**From:** [Alex Hawtin](#)  
**To:** [Metrowest1](#)  
**Cc:** [Bartkowiak, Bart](#); [Gary Collins](#)  
**Subject:** Portishead Branch Line - MetroWest Phase 1 - Bristol City Council response to Deadline 5  
**Date:** 16 February 2021 18:31:58  
**Attachments:** [Bristol City Council - Response to ExQ2 - ISSUE.pdf](#)

## Portishead Branch Line – MetroWest Phase 1

### Bristol City Council's Responses to the ExA's Second Round of Written Questions

This document outlines Bristol City Council's ('BCC') responses to the Examining Authority's (ExA) second round of written questions ('ExQ2'), issued on 26 January 2021. The following table outlines the questions considered relevant to BCC and the City of Bristol only.

2.47 - Ashton Vale Road and Winterstoke Road Highway Works Plan

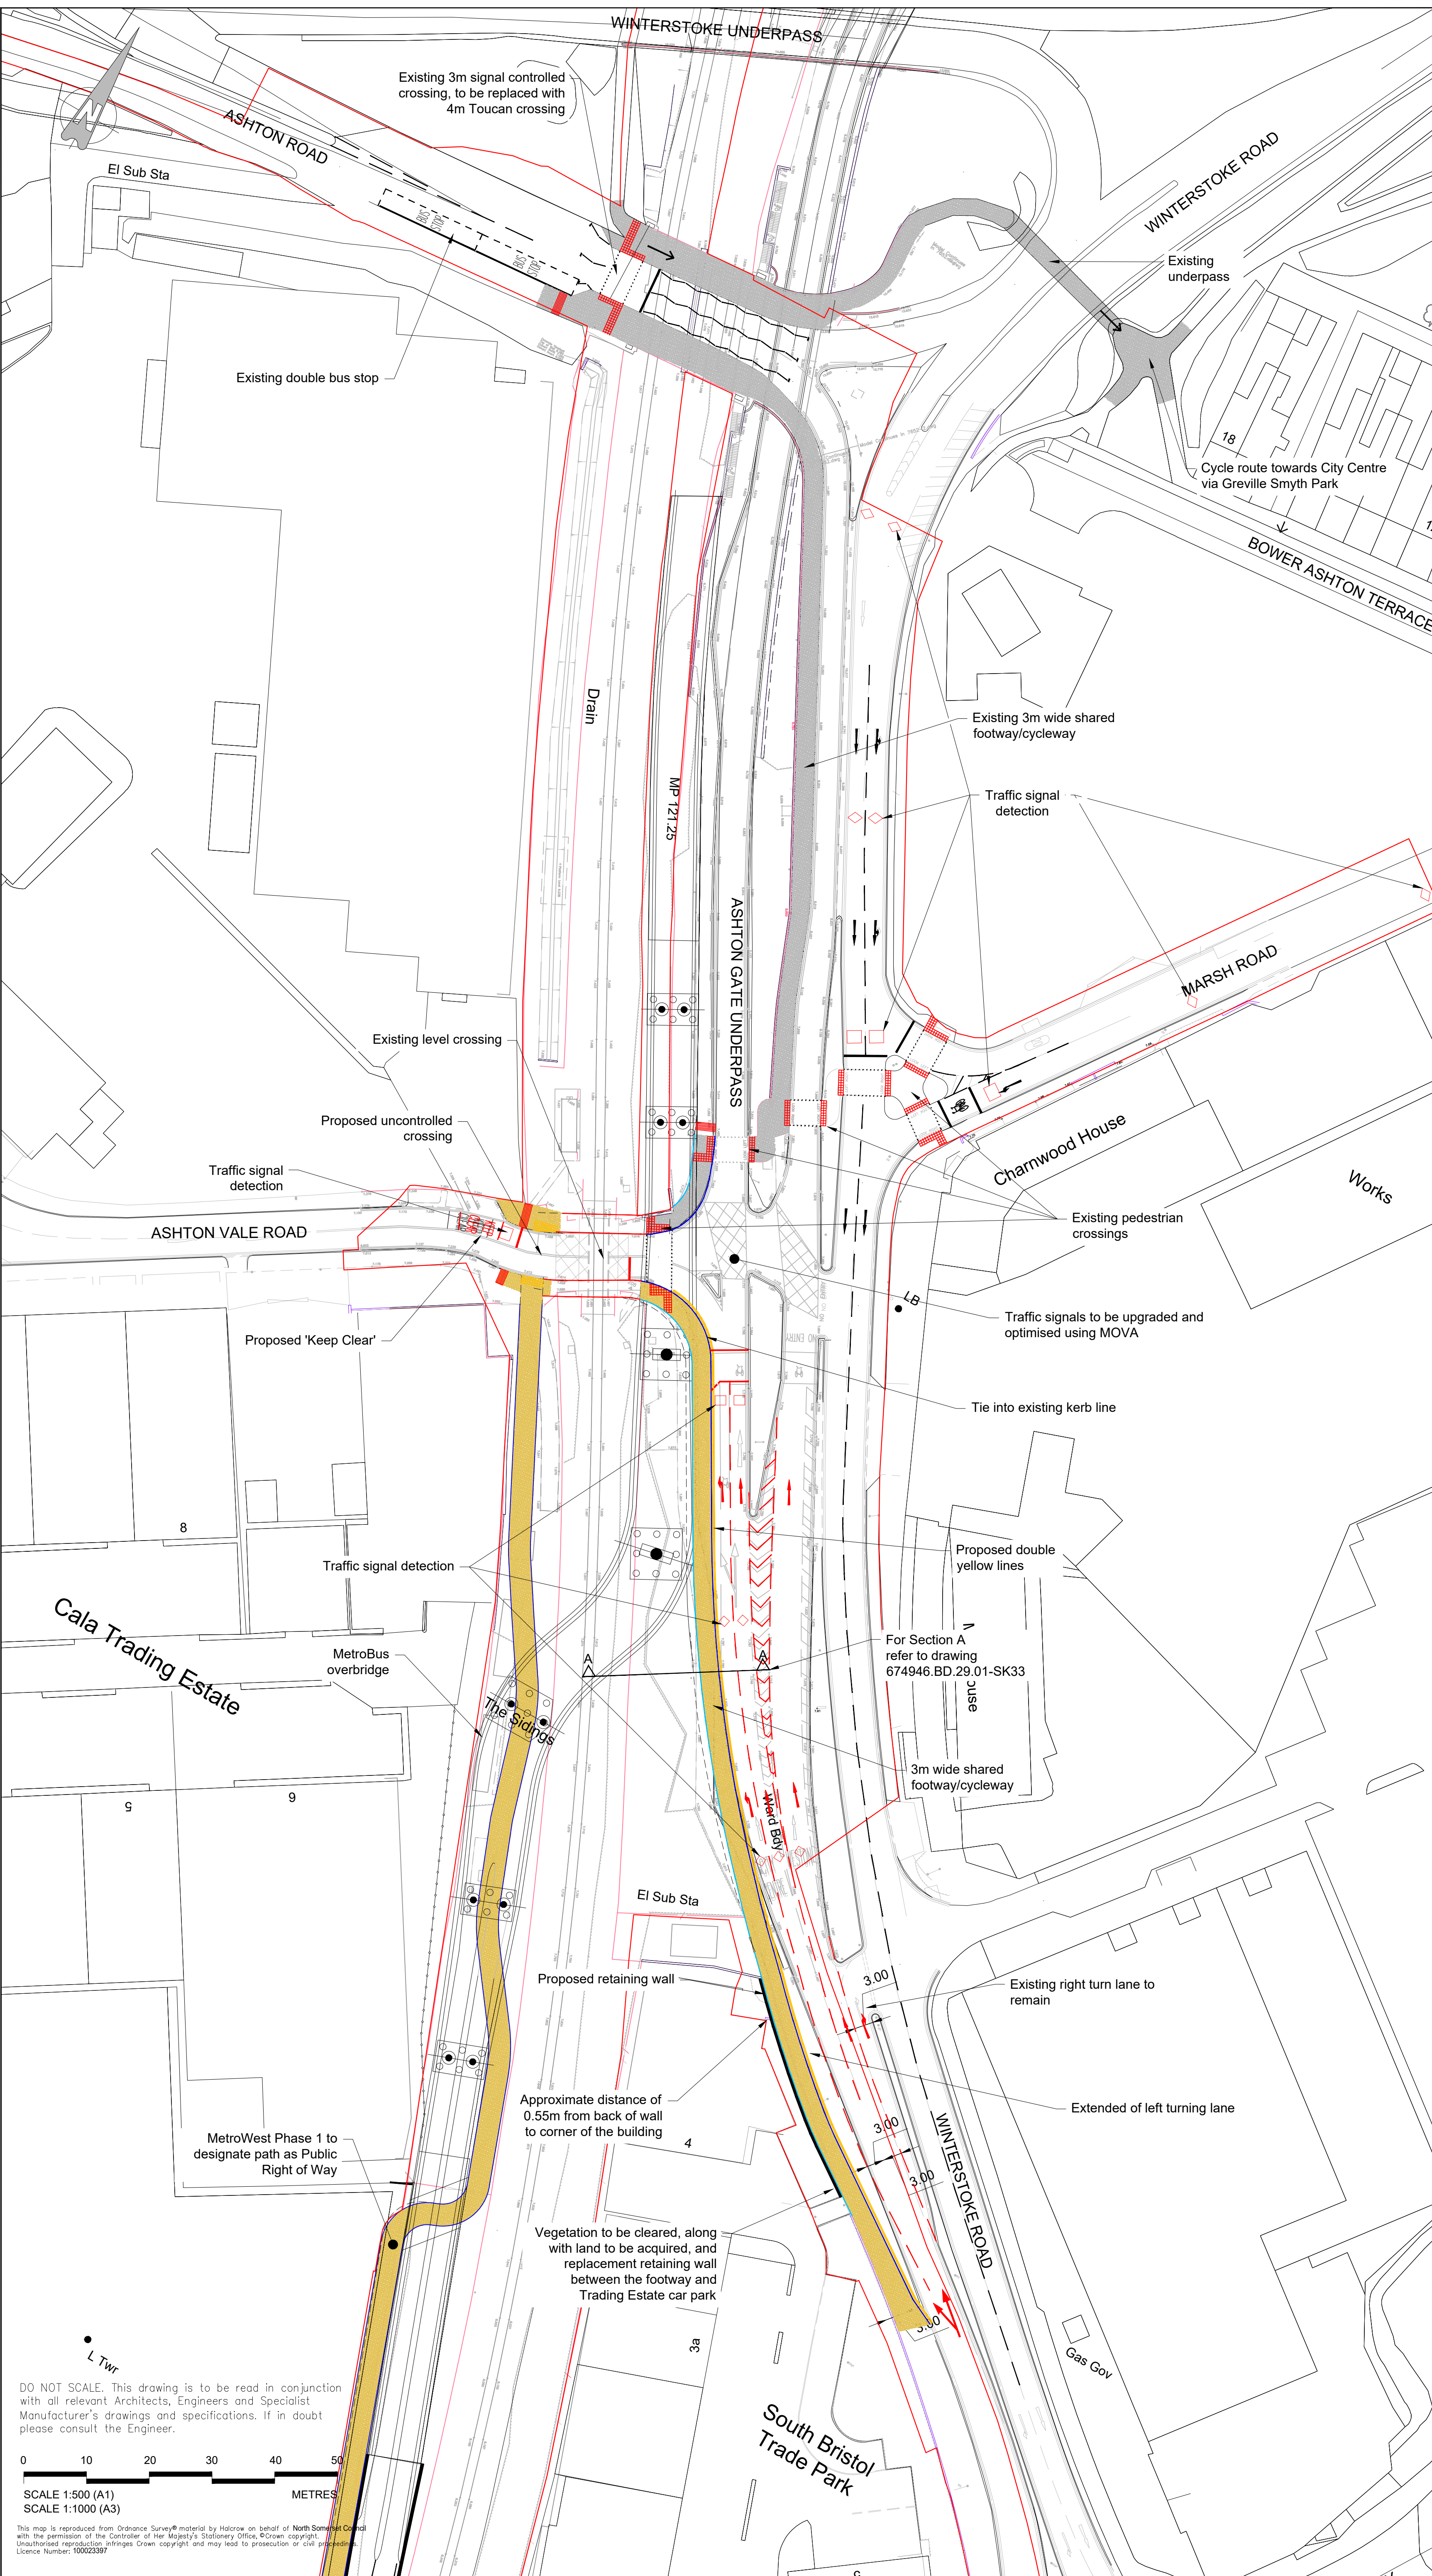
24. BCC to review their comments on the Winterstoke Road/ Ashton Road junction in light of the response received from Mr Tonks at Deadline 4.	See attached response to ExQ2.
<b>ISH2</b>	
<b>Action Point</b>	<b>BCC's Response</b>

ExQ2 Ref	Question to:	Question:	BCC Response:
Traffic and Transport			
TT.2.2	<p>M5 Junction 19</p> <p>North Somerset District Council</p> <p>Bristol City Council</p>	<p>The draft DCO [REP3-005] includes a new requirement no. 30 relating to M5 Junction 19 following the SoCG with Highways England [REP1-019]. Could the Highway Authorities both confirm that they are satisfied with the wording of the requirement and if they have any further comments in relation to the M5 Junction 19.</p>	<p>Requirement 30 of the draft DCO [REP3-005] relates to Works Nos. 1 to 24A. Each of these works is located within North Somerset District and as such, BCC has no comments on the wording of this requirement.</p> <p>BCC is satisfied that construction traffic and travel impacts can be sufficiently mitigated by provision within Requirement 5 (4) and (5) of the Draft DCO.</p>
TT.2.5	<p>Work No 28 &amp; Ashton Vale Road crossing</p> <p>Bristol City Council</p>	<p>Provide comment on the submissions by CTC and Sutherland Property and Legal Services (SPLS) [REP4-050], in particular regarding:</p> <p>The recent and future expansion of existing businesses around Ashton Vale Road and whether this 'stress testing' should be accounted for in the TA; and</p> <p>The 'Agent of Change' and fallback position of increased use of the railway line by freight trains.</p>	<p>As outlined within BCC's Local Impact Report [REP1-032], BCC is satisfied with the Applicant's approach to traffic modelling at Winterstoke Road and Ashton Junction and the mitigation proposed by the Applicant.</p> <p>The methodology for the traffic modelling undertaken to inform the Applicant's Transport Assessment was agreed with BCC's Traffic Signals team and as such, the model is acceptable.</p> <p>The submissions by Sutherland Property &amp; Legal Services on behalf of ETM Contractors Ltd and Manheim Auctions Ltd ('the representations') appear to rely on a limited set of data rather than the full scope of surveys which were undertaken by the Applicant by both Manual Classified Counts and Automatic Traffic Counts. These surveys were largely consistent in terms of volumes and patterns and again are considered acceptable to BCC.</p> <p>The representations outline that the temporary roadworks on Winterstoke Road would invalidate the surveys undertaken due to the unavailability of the left turn lane into the Ashton Vale Estate. The assumption within the representations is contrary to BCC's understanding given the range of surveys undertaken across several years both with and without the temporary roadworks, and the fact that the traffic volumes going into and out of the Ashton Vale Estate would be unlikely to change significantly due to the roadworks as there is no alternate route for traffic (Ashton Vale Road is the only way to access to the Estate).</p> <p>On the subject of sensitivity testing or stress testing, the approach undertaken by the Applicant and the use of a Vissim model would account peaks such as the auction programme. This approach is in accordance with the Department for Transport's 'Transport analysis guidance' (TAG). The auction peak would also not coincide with the typical PM traffic peak and as such, the effect of these events on the modelling would not be significant.</p> <p>The MOVA control upgrade proposed by the Applicant would help to address any peaks, such as those encountered at auction events or at the AM or PM traffic peaks. This form of mitigation is considered acceptable to BCC.</p> <p>With regard to the 'Agent of Change' principle, whilst this is typically associated with pollution-generating uses, the principles could be applied to the situation at the Ashton Vale Estate.</p> <p>Firstly, para. 182 of the NPPF states that existing business should not have unreasonable restrictions placed on them by development. As the railway line</p>

ExQ2 Ref	Question to:	Question:	BCC Response:
			<p>and the level crossing are already in existence, the element of change would be the frequency of closures associated with an increase in the use of the line.</p> <p>The transport modelling, which has been agreed with BCC, does not indicate that the junction would function any worse than existing and as such, it is not considered that any 'unreasonable restrictions' would be placed on the businesses within the Ashton Vale Estate.</p> <p>The second element of para. 182 requires the provision of 'suitable mitigation' to respond to the agent of change. The mitigation proposed, in the form of the upgrade to the MOVA system and the increase in the length of the left turn lane onto Ashton Vale Road, is considered acceptable by BCC.</p>
